Recommendation Report for Planning Permission for Works or Extension to a Dwelling

REF NO: BN/4/22/HH

LOCATION: Kenwood
Barnham Road
Eastergate
PO20 3RS

PROPOSAL: Erection of two storey side extension, front porch, installation of front boundary wall and gate and widen existing crossover.

North East Elevation
Indicating Proposed Gate and Pillars

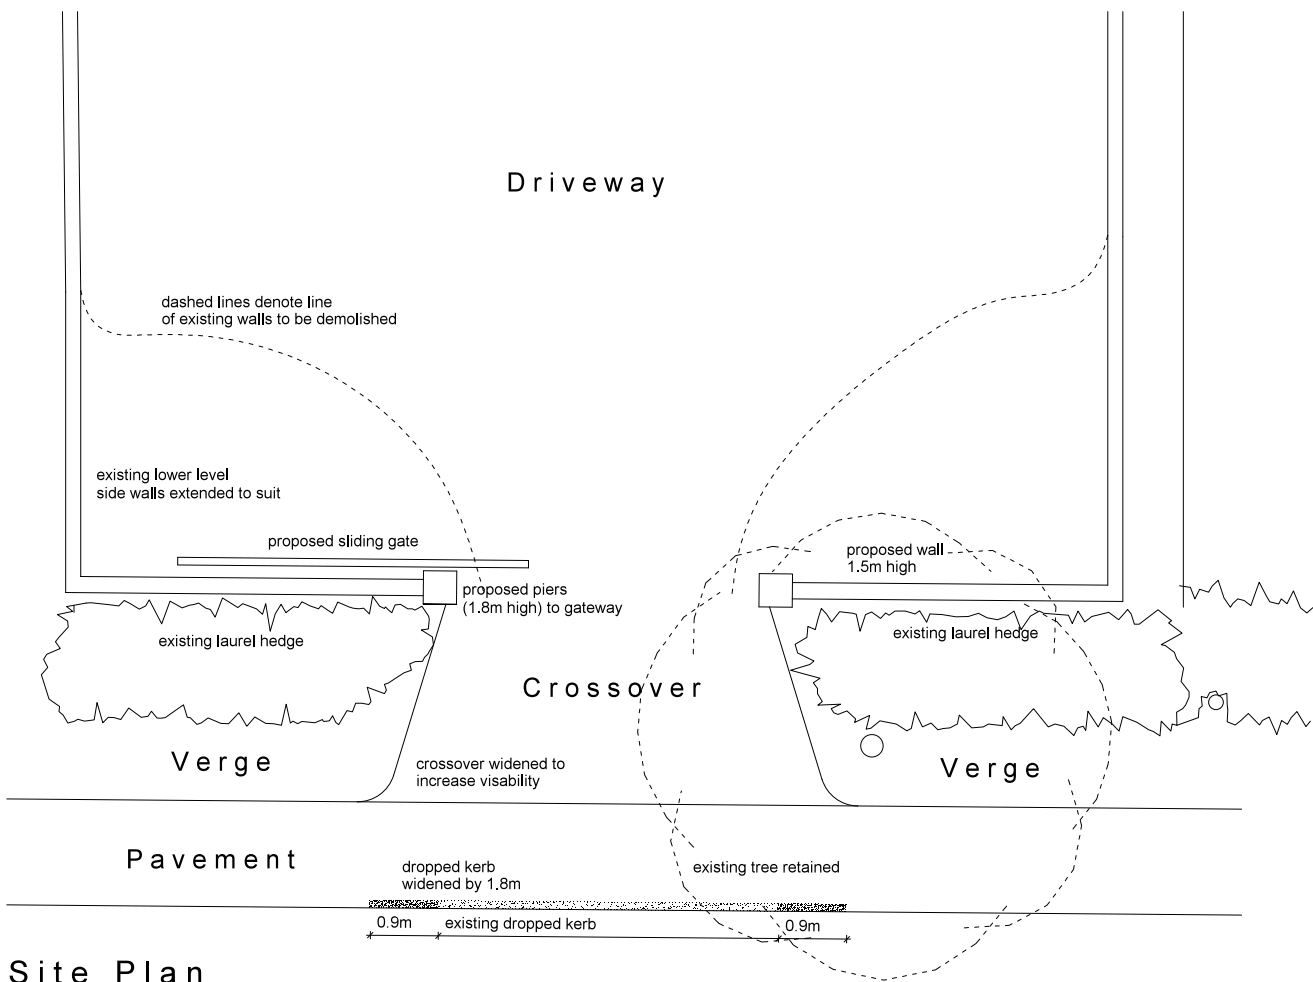
The gates to the front will run along the vehicular entrance with a width of around 4m. These will have a height of 1.5m, with the pier either side to 1.8m. This is set slightly back from the pavement and is considered acceptable with the gate appropriate in height. There are some varied boundary treatments present along the road featuring hedges and fences and the development will not adversely impact the street scene.

North East Elevation

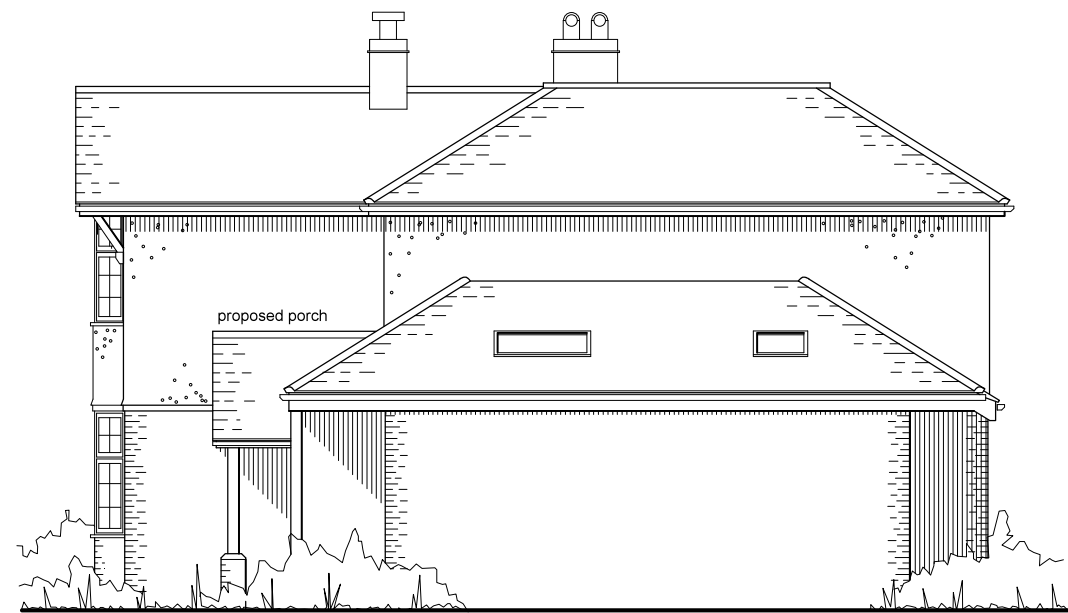
The two storey extension will be to the east elevation and will have barn hip roof to match the dwelling. It also features a front dormer. This has a pitched roof and appears in keeping with the design of the property which has a gable projection to the front centre. The extension does not extend beyond the principal elevation and appears a sympathetic addition. Materials match existing to further assist with its integration with the dwelling.

Drawing P01 December 2021 Scale 1:100 @ A3
Planning Drawing - Floor Plans & Elevations

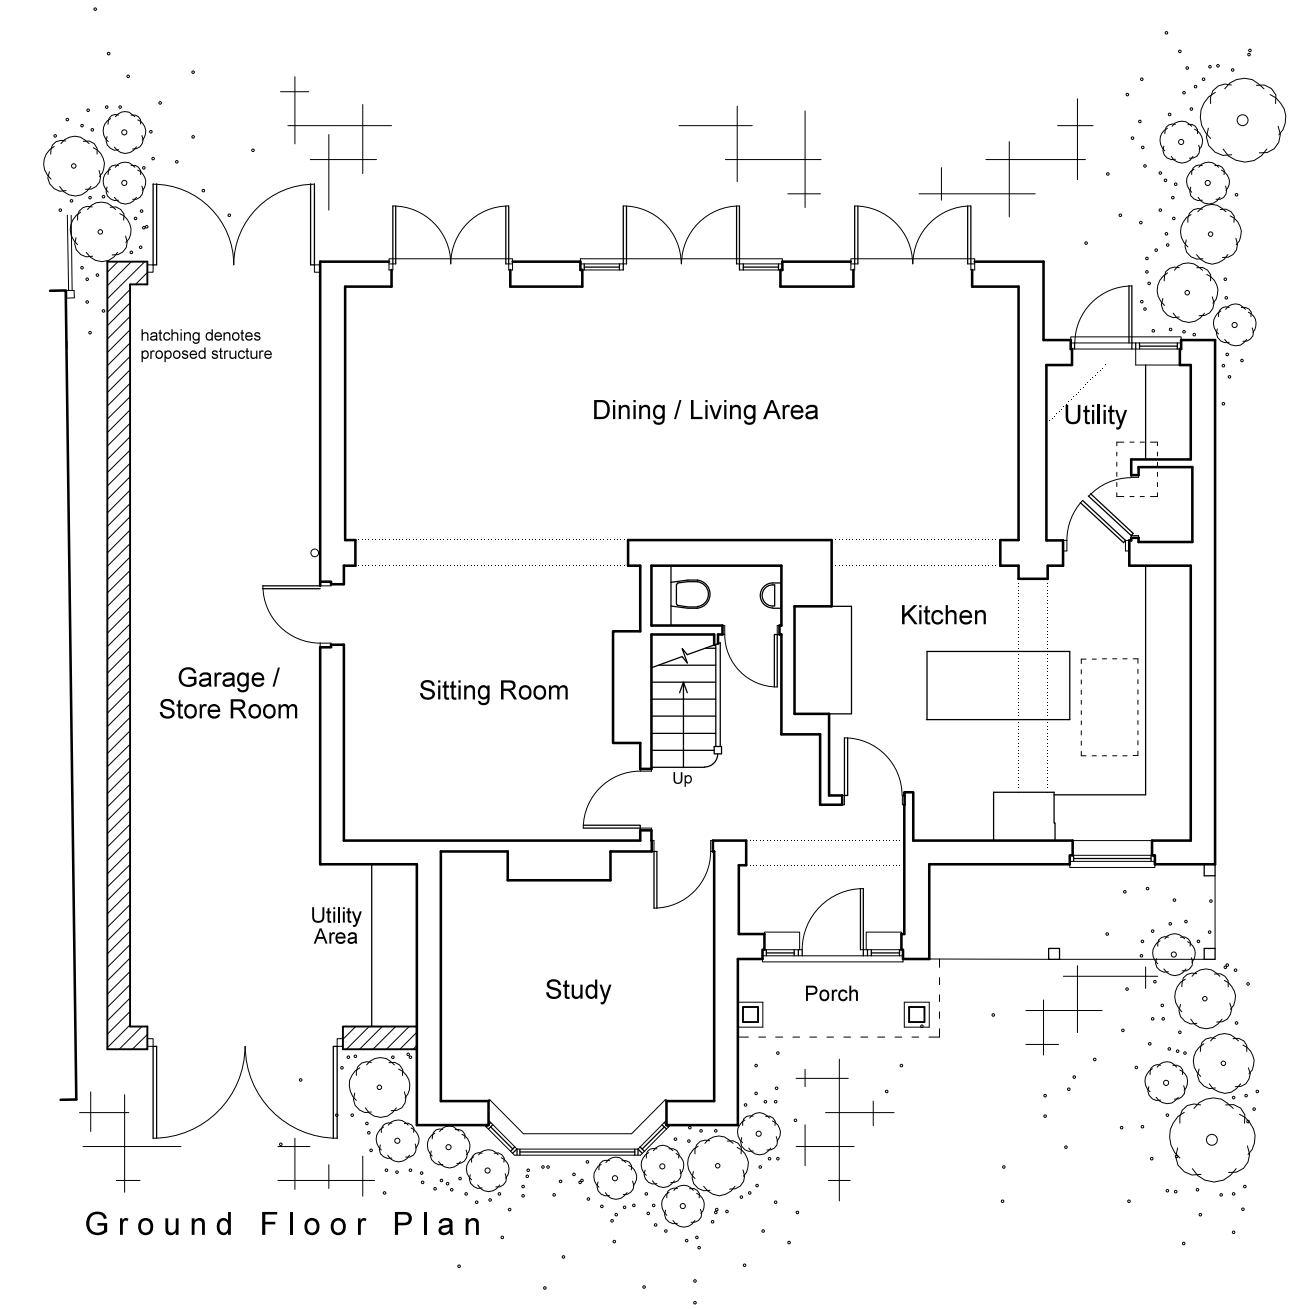
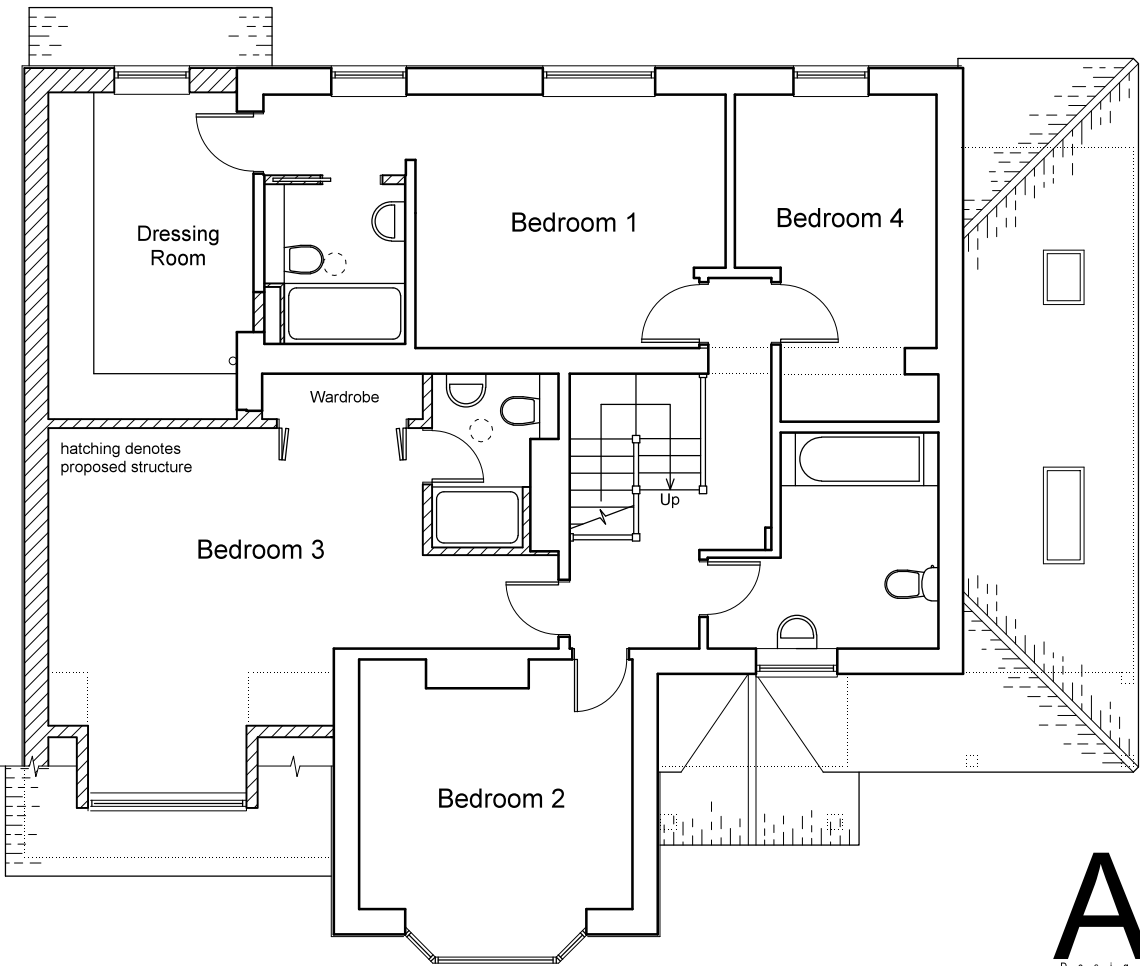
The Arun Design Guide states 'Avoid a terracing effect by setting side extensions back from the front of the house, keeping these 1 metre from side boundaries at ground floor and 2 metres above'. The proposal does not retain 1m to the side boundary with only a gap of 0.45m and does not comply with this

element. To the neighbouring side there is a single storey garage at the boundary and therefore whilst the property is in closer proximity, it does not result in a terracing effect when looking at first floor level.

The two storey extension will have a width of 4m which reduces to around 2.7m as it extends along the side and meets with the rear building line. The roof will meet with the ridge of the dwelling with a hip sloping away from the boundary. The neighbouring property at 'Hallfield' has a window to the first floor western side which will be subject to some overbearing impact as a result of proposal. The windows current view is predominately towards the side of the host dwelling and views will largely remain the same, albeit the building will be in closer proximity and as such the impact is not considered significant.

The extension will incorporate a garage. Under ADC Parking standards garages should have a width of 3m however the proposed width is only 2.5m. Due to the limited space retained to the boundary, increasing the width of the garage does not appear to be achievable. The garage would not be classed as a parking space. There is sufficient space to the front for around 3-4 cars and the proposal would not result in harm upon the parking in the area.

Visibility Splay Diagram
Scale 1:500

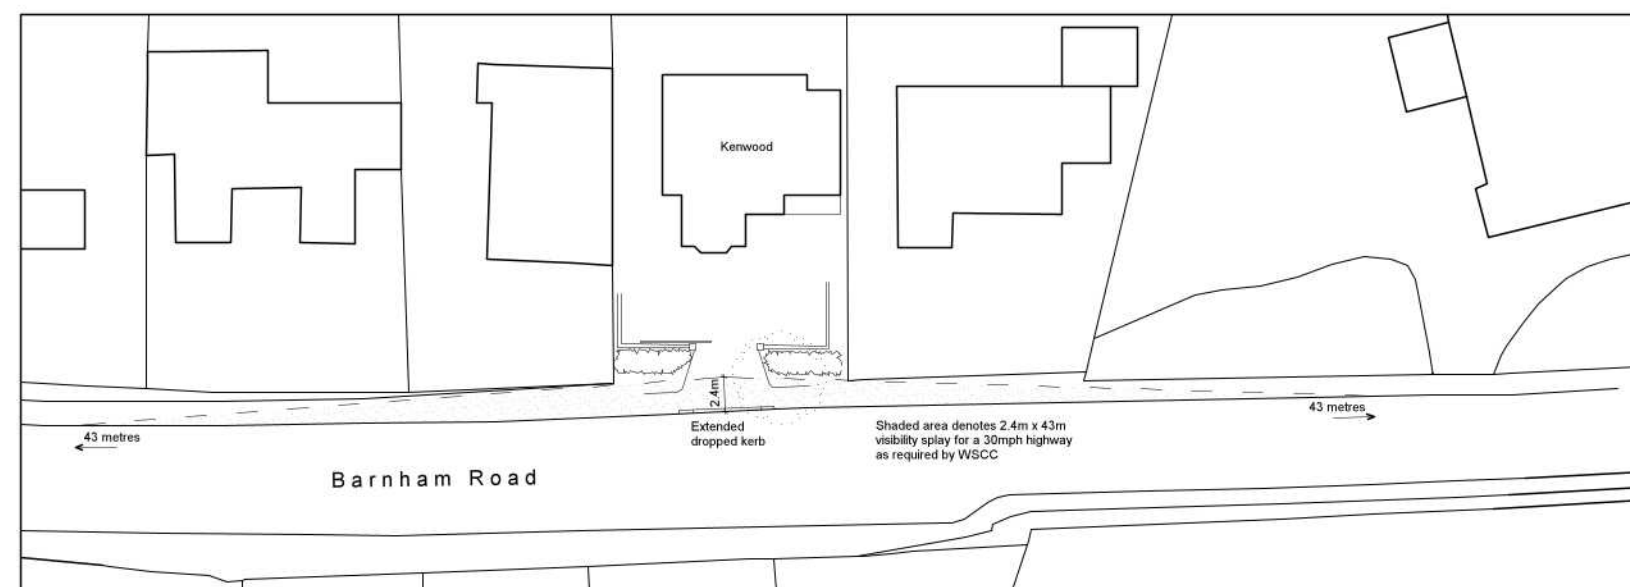
The widening of the crossover has been checked by WSCC and is acceptable and is a similar arrangement to neighbouring properties. The proposal complies with TSP1 of the Arun Local Plan.
